FULL

Reference: H09-0445-16 **Date of Decision:** 26th July 2016
Applicant: Mrs A Wright
5 Colin Close
West Wickham
Kent
BR4 9JP

Location: The Crown Hotel Car Park West End Holbeach Spalding
Description: Pair of semi-detached dwellings on part of The Crown Hotel car park

FRONT ELEVATION

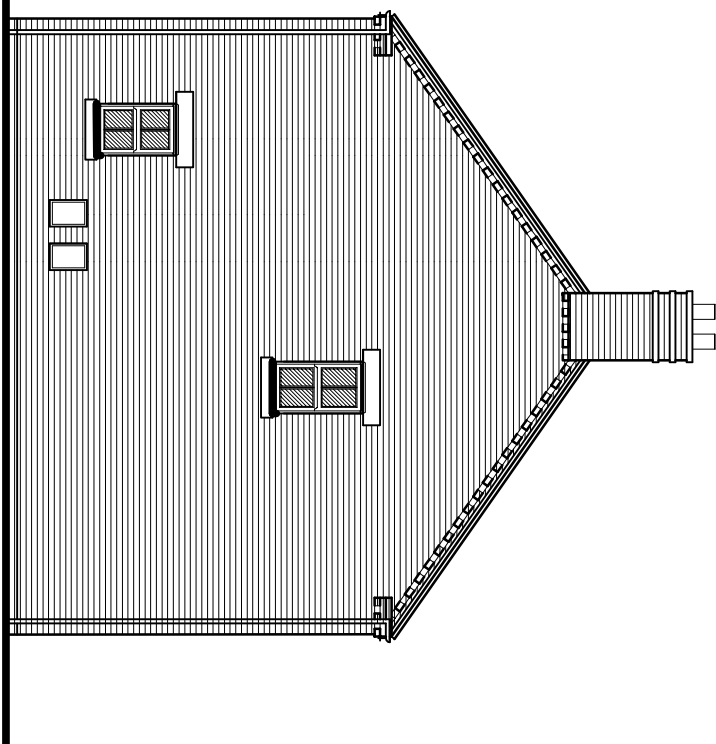
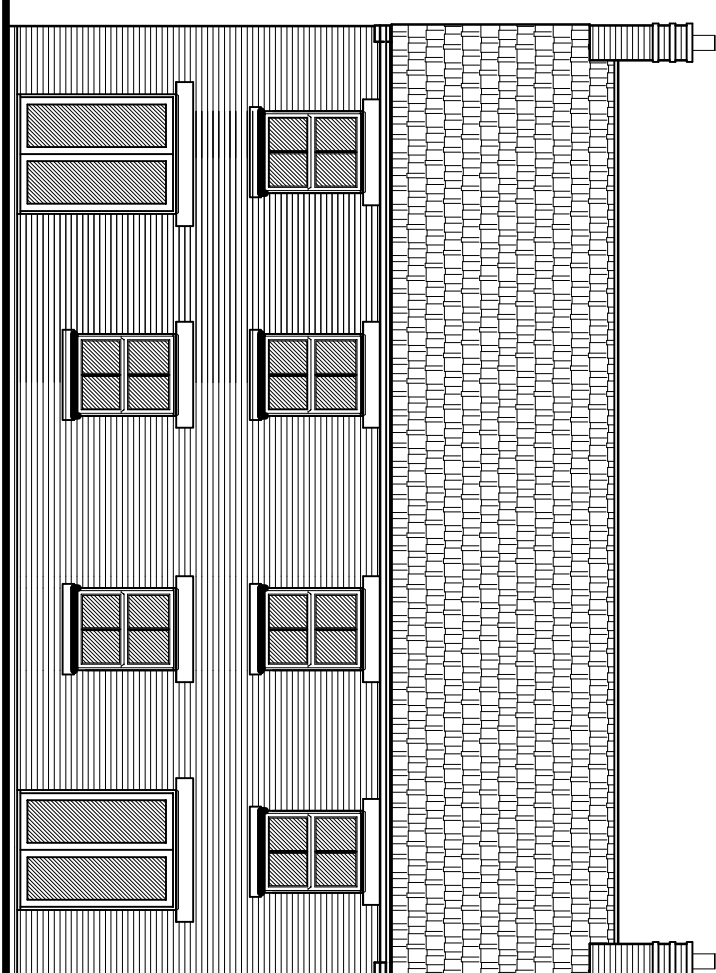
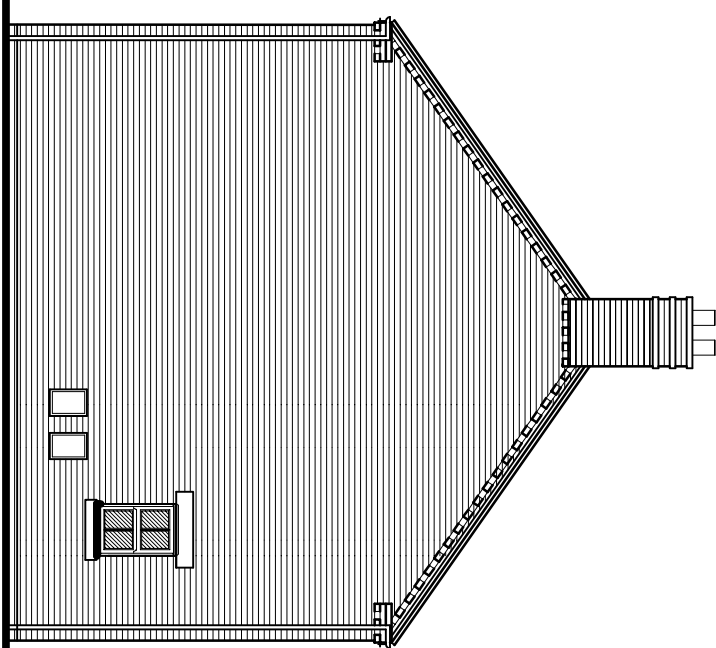
- 5 The new brickwork shall be constructed in English Bond on the front elevation of the dwelling and English Bond or English Garden Wall Bond (ratio 1:3) on the side and rear elevations.

- 8 All new window frames, glazing bars and external door frames shall be of timber construction and painted cream or white. They shall thereafter be so maintained.

- 9 The external face of the frame to all new windows shall be set in a reveal of 100mm from the front face of the adjacent walling and thereafter so maintained.

- 12 The guttering to the development hereby permitted shall be fixed to the external walls by means of gutter spikes/rise and fall brackets and no fascia boarding shall be used.

- 14 External boxes for gas and electricity supplies shall be installed in accordance with the submitted details. They shall not be installed on the front (Northern) elevation.

SITE PLAN 1:200

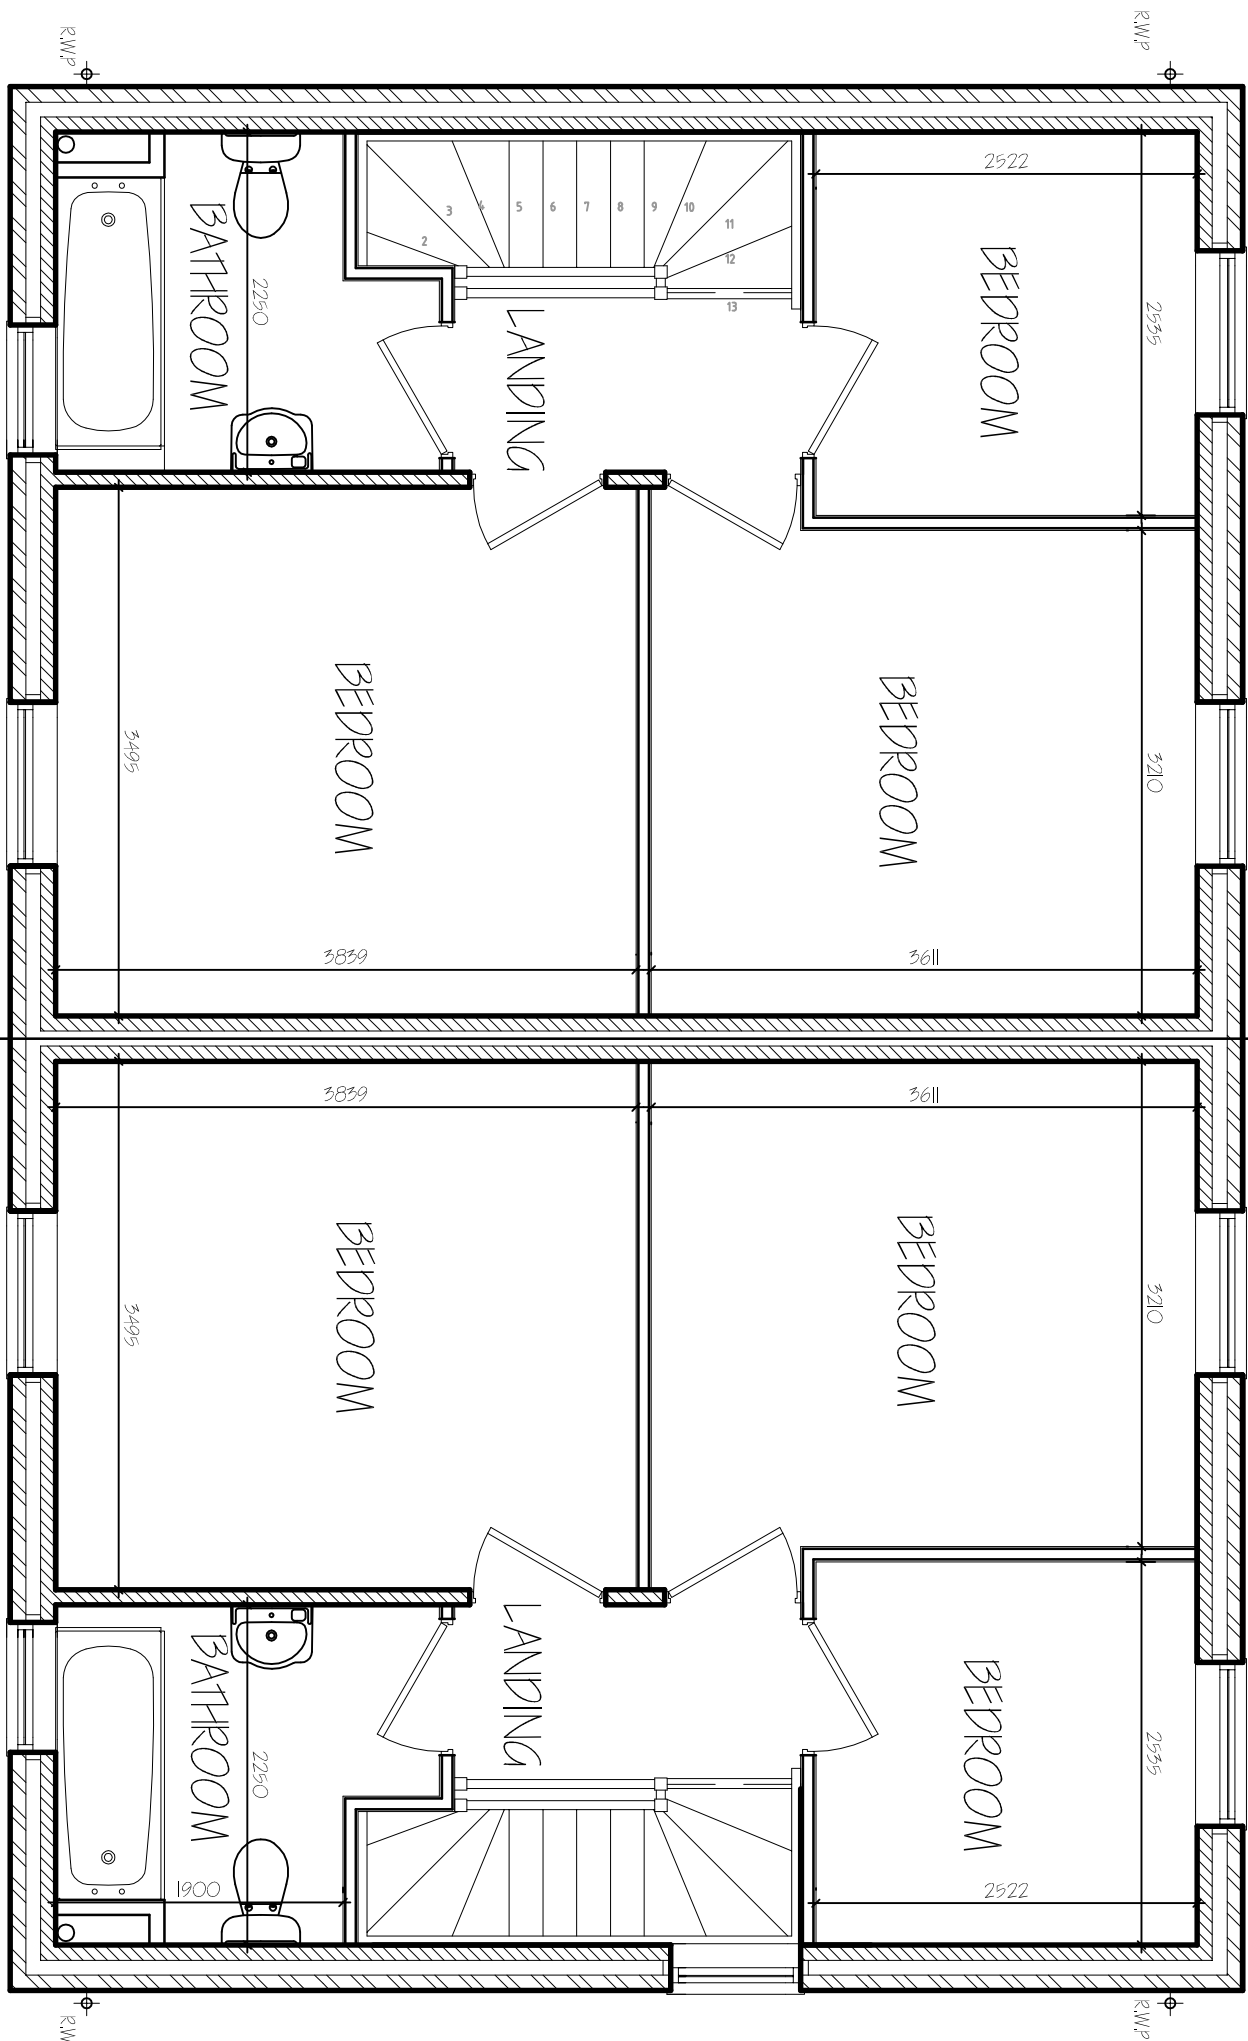
- 15 Prior to occupation of any dwelling the metal railings along the northern, eastern and western boundaries shall be installed and painted black in accordance with details to be submitted to and approved in writing by the Local Planning Authority. They shall thereafter be retained.

- 16 Before either dwelling is occupied the garden wall along the eastern boundary of the site shall be constructed in accordance with details to be submitted to and approved in writing by the Local Planning Authority. The walling shall be constructed in garden wall bond to a ratio of 1:3 or 1:5.

- 18 Before the dwellings are occupied, the parking areas shall be completed in accordance with the approved details and retained for that use thereafter.
